Application Ref:	3/2025/0275			 Ribble Valley Borough Council www.ribblevalley.gov.uk
Date Inspected:	12/08/25	Site Notice:	N/A	
Officer:	LW			
DELEGATED ITEM FILE REPORT:				APPROVAL

Development Description:	Proposed conservatory to side.
Site Address/Location:	Clementina, Barker Lane, Mellor, BB2 7EE.

PROPOSED CONSERVATORY TO SIDE (southeast) ELEVATION
width 3m, projection 3m, hgt to eaves 2.65m, hgt to ridge 3.4m
external walls to be facing brick (to match existing conservatories),
frames/rafters white upvc, glazing clear, roof material polycarbonate

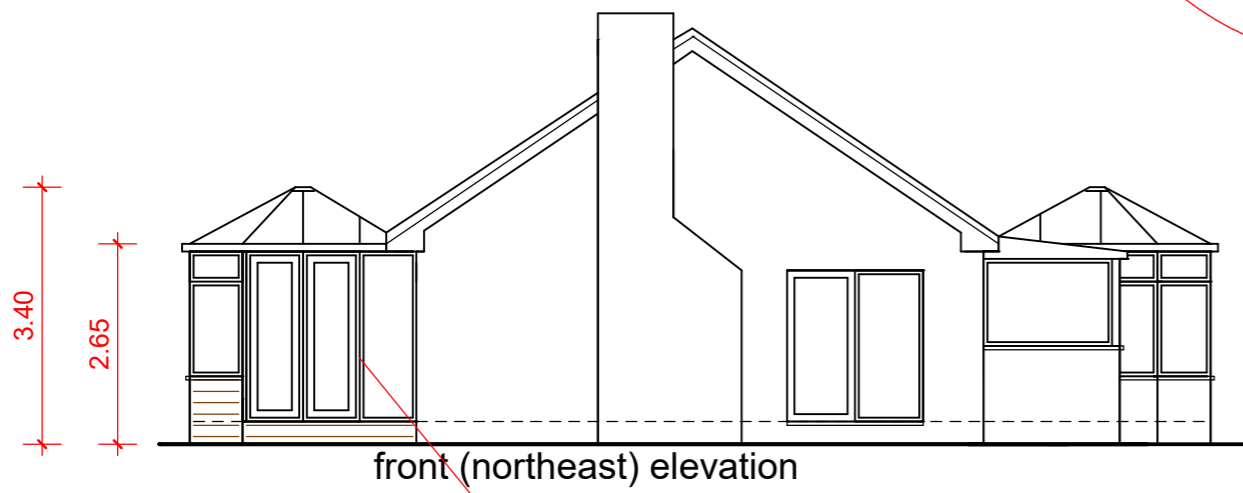
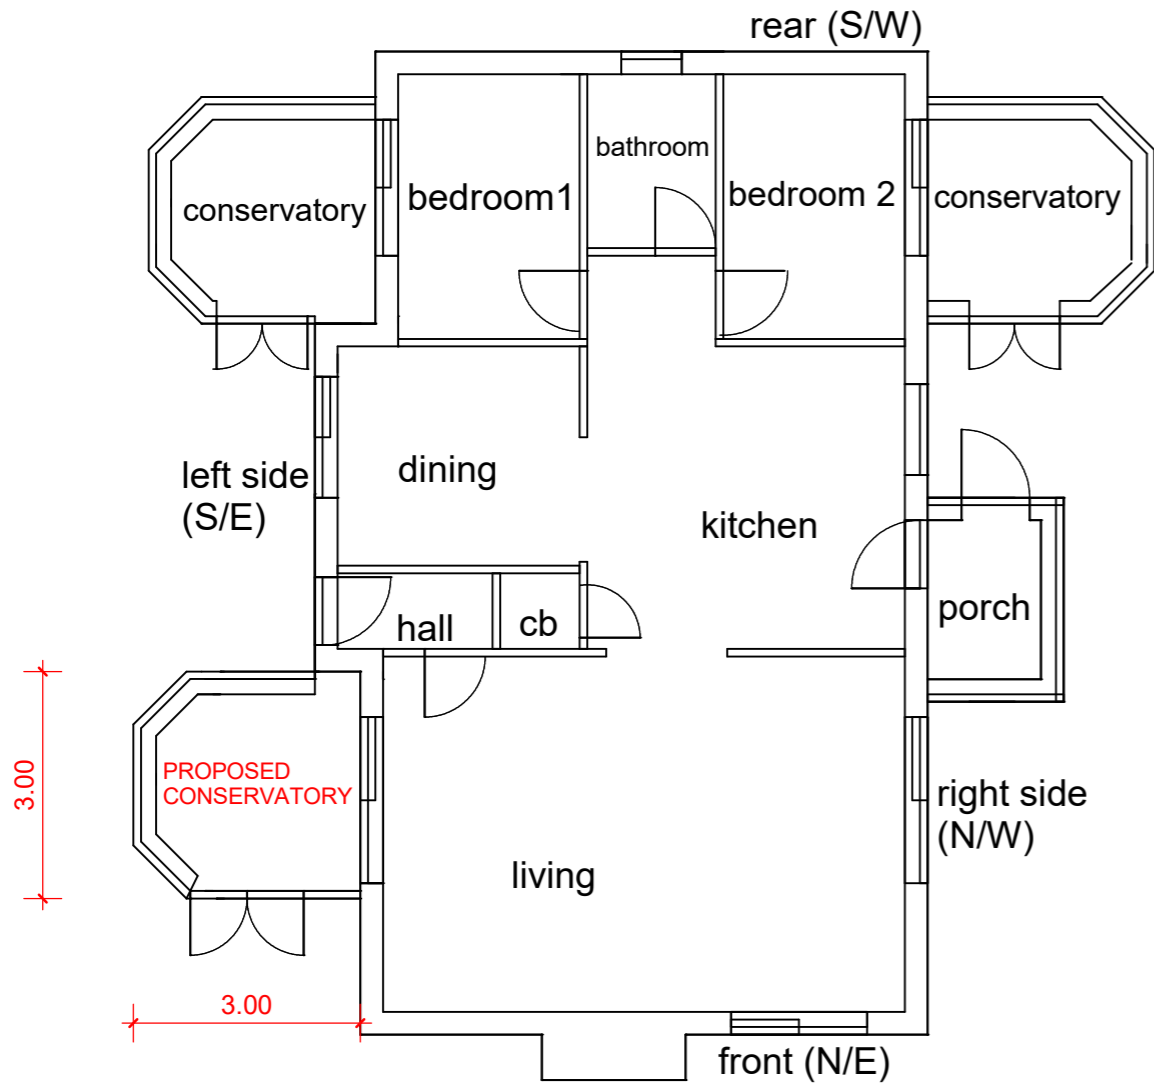
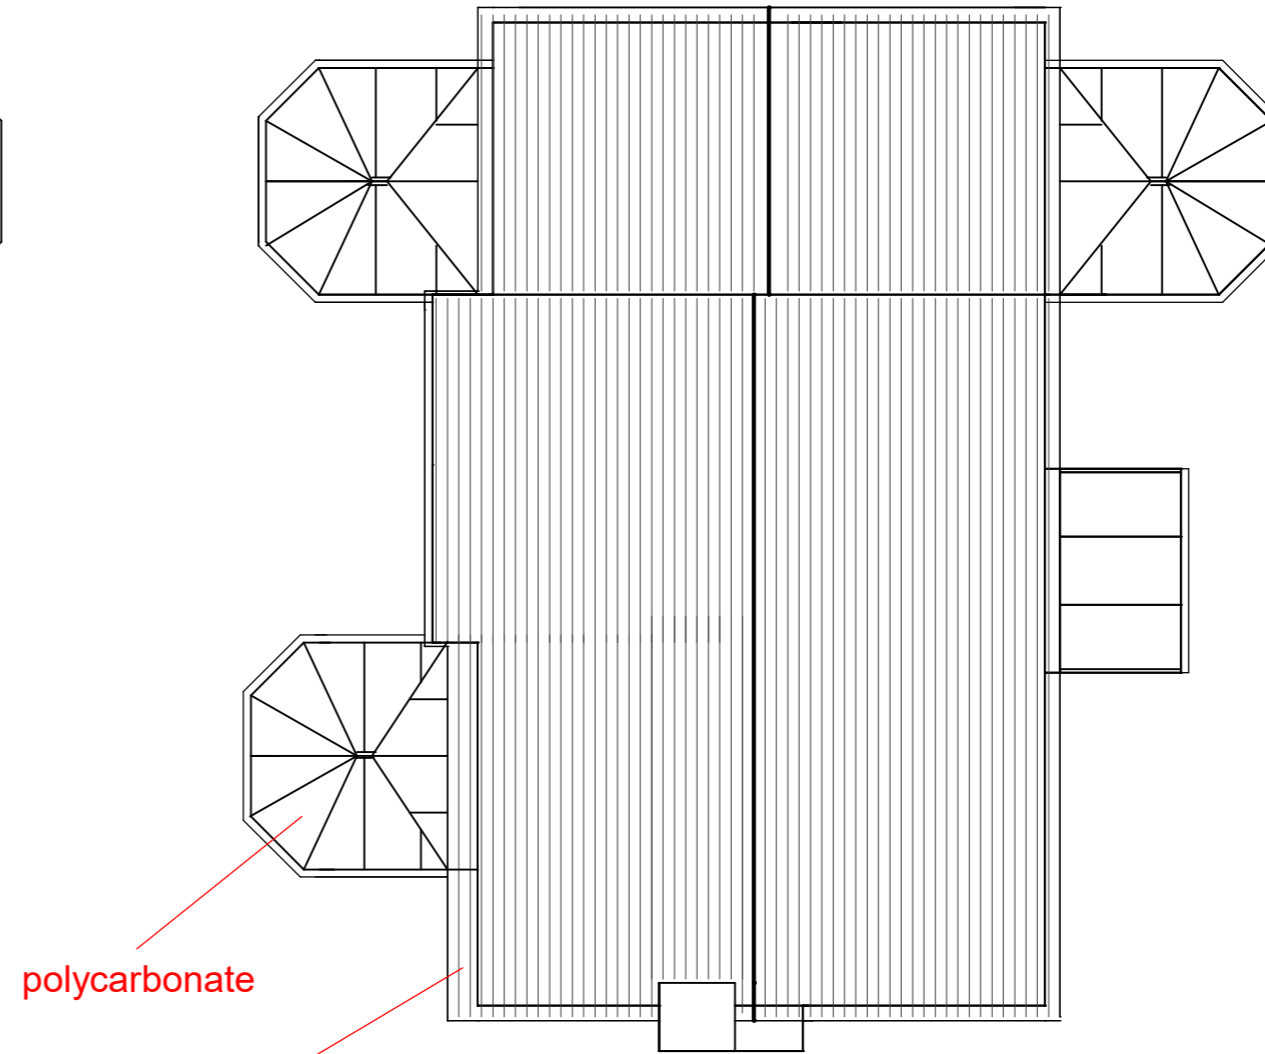
Notwithstanding the above, volume calculations have been submitted in support of the application, taking account of the original building, the existing extensions and the proposal. These calculations indicate a 52% increase in cubic volume from original to existing, with the proposed extension resulting in a further 8% increase. This equates to a total increase in cubic volume from the proposal and aforementioned historic additions of 60%. With the above in mind, it is considered that the proposed works would result in a disproportionate addition to the original building in as much that the cumulative cubic volume increase of the additions would be significant in relation to the original built form.

Furthermore, there is no definition of openness in the NPPF but, in the Green Belt context, it is generally held to refer to freedom from, or the absence of, development. The degree of harm to openness is normally reliant on a spatial judgement, however, visual considerations can also be relevant. In this instance, the proposed development would result in an extension of the footprint of built form which would be visible from the public highway of Barker Lane, thus resulting in a clear impact upon the openness of the Green Belt.

Taking account of the above, it is considered that the proposed development would result in Green Belt harm contrary to the guidance set out in Paragraph 154 of the NPPF and Key Statement EN1 of the Ribble Valley Core Strategy. Furthermore, no very special circumstances have been demonstrated which would outweigh this harm.

The proposal would be sited towards the south-eastern corner of the property and would therefore be visible from the public highway of Barker Lane. Despite this, the proposal would not appear an anomalous or discordant addition to the proposal site or surrounding area. The conservatory would be relatively modest in design and would be finished in external facing materials to match the existing conservatories featured to the front and rear of the property. Accordingly, the proposal is considered acceptable with respect to visual amenity and external appearance.

RECOMMENDATION:	That planning consent be refused for the following reason:
01:	The proposed development would result in a disproportionate addition to the original property in as much that the cumulative volume increase of the previous extensions and current proposal would be significant in relation to the original property. The proposal is therefore considered to cause harm to the openness of the Green Belt contrary to the provisions of Key Statement EN1 of the Ribble Valley Core Strategy (2008-2028) and Section 13 of the National Planning Policy Framework which attaches substantial weight to Green Belt harm.
